# **A12 Chelmsford to A120 widening scheme**

**TR010060**

## **DEVELOPMENT CONSENT ORDER CHANGE APPLICATION**

### **Change Application Summary Report**

Map Book 2: Anglian Water Pumping Station (Bury Lane, Hatfield Peverel)

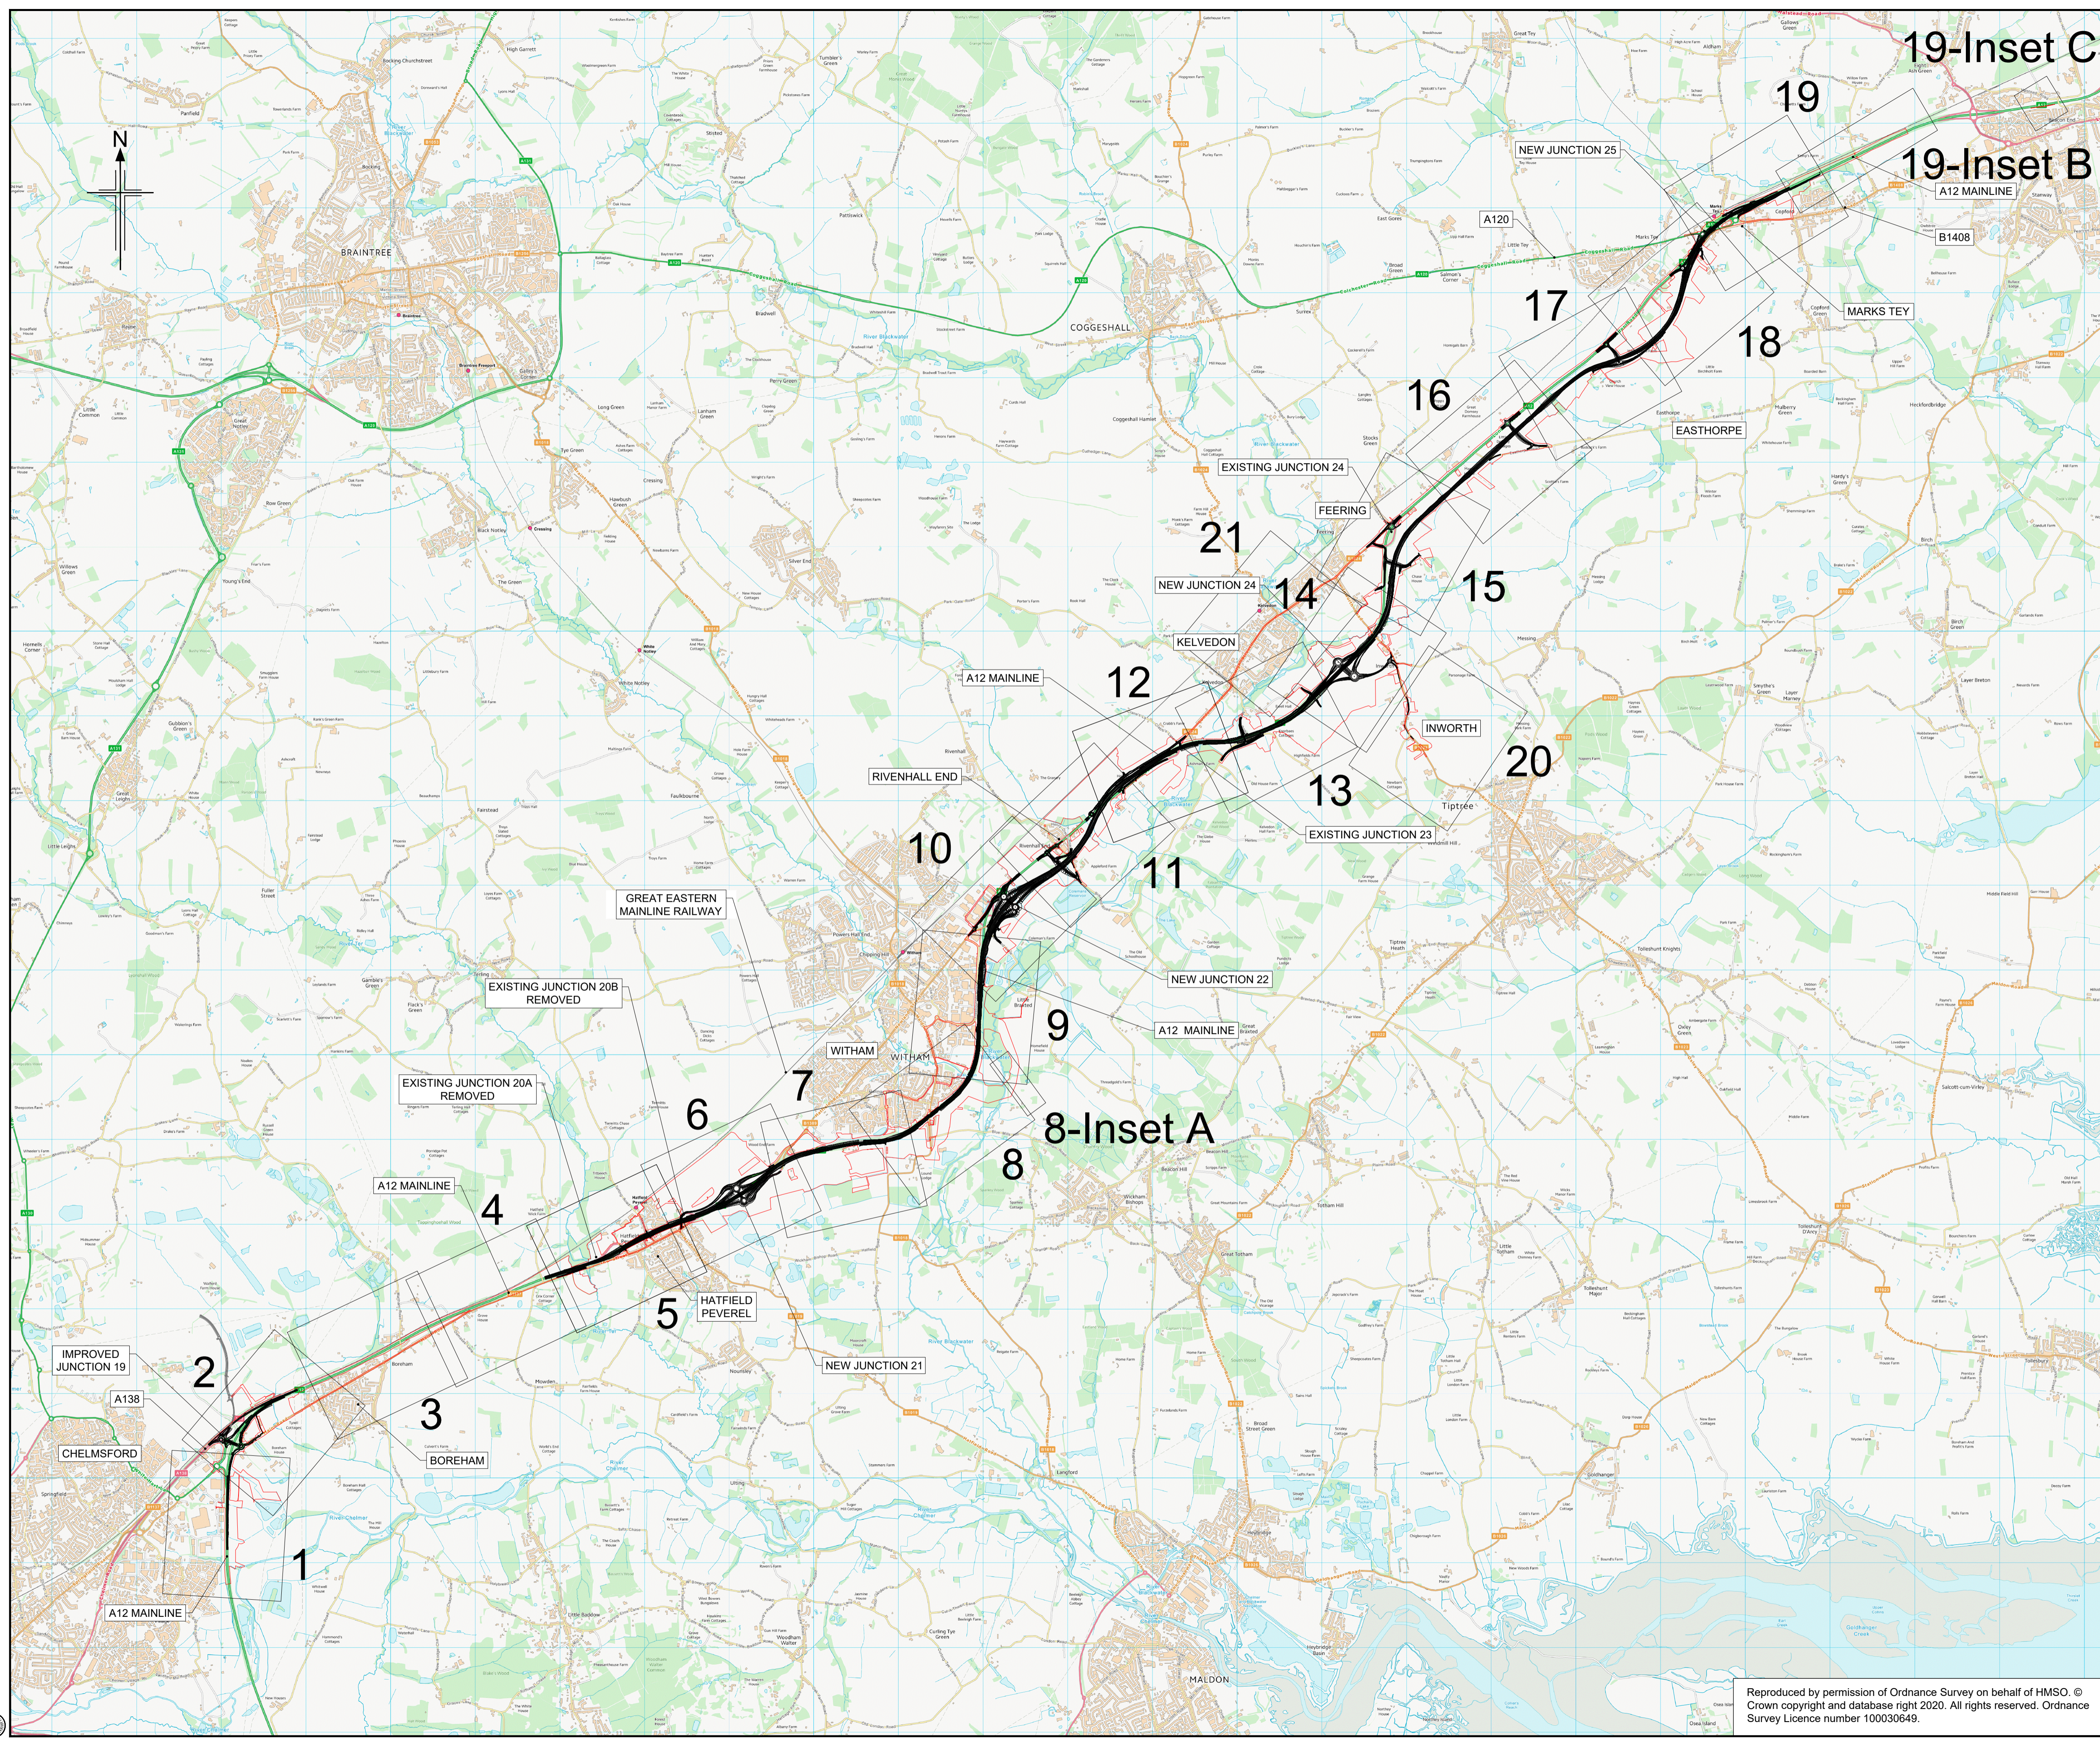
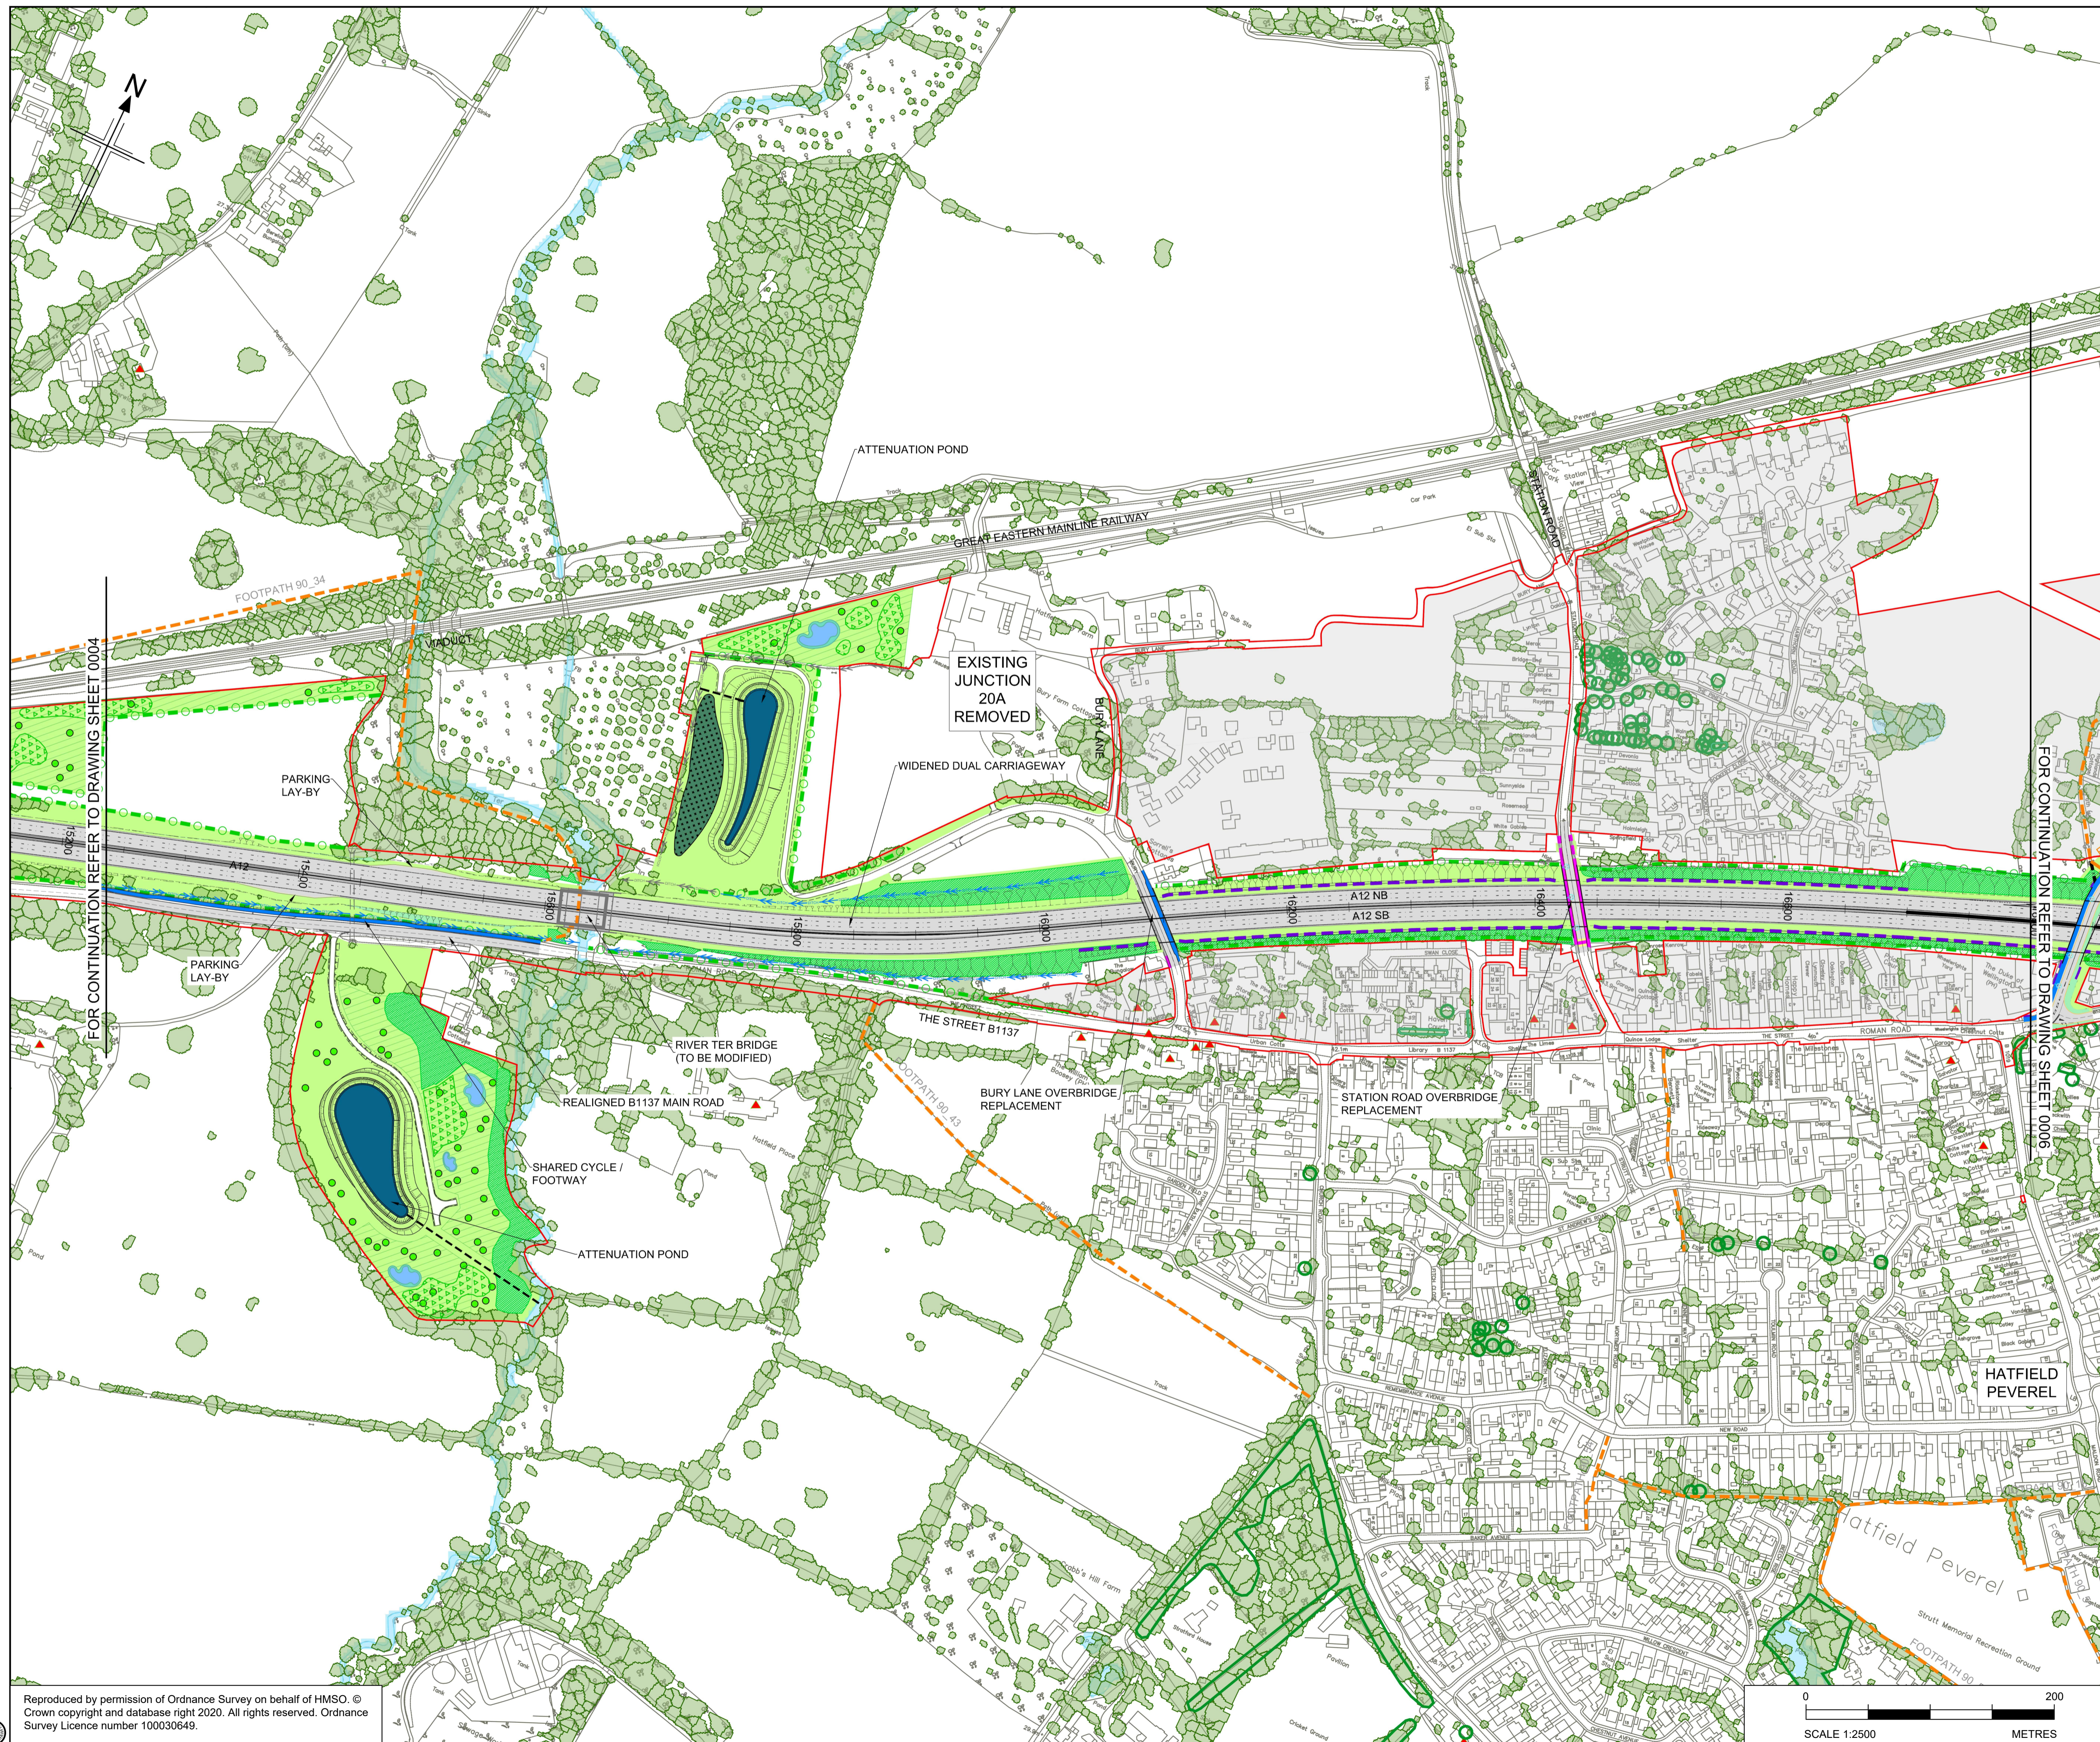
- 2.3.1 The proposed change is to the extent of an Environmental Mitigation Area as shown on the General Arrangement Drawings (Map Book 2) [TR010060/EXAM/10.6] to accommodate a pumping station at the Bellway Homes Site, Hatfield Bury Farm, Bury Lane, Hatfield Peverel (planning permission 19/01803/FUL). This falls within the Order Limits of the proposed scheme and specifically land plot 5/12c as shown on Sheet 5 of the Land Plans [APP-018].
- 2.3.2 The Applicant proposes to change the land use at this location from compulsory acquisition for ecological mitigation, to, land not subject to powers of compulsory acquisition or temporary possession. The small area of ecological

mitigation that will be lost is a negligible decrease in the overall land being provided for ecological mitigation across the whole proposed scheme.

2.3.3 This design change is illustrated in Figure 2.2 and shown on Map Book 2 – Anglian Water Pumping Station (Bury Lane, Hatfield Peverel) - Part 1 of 1 [TR010060/EXAM/10.6].
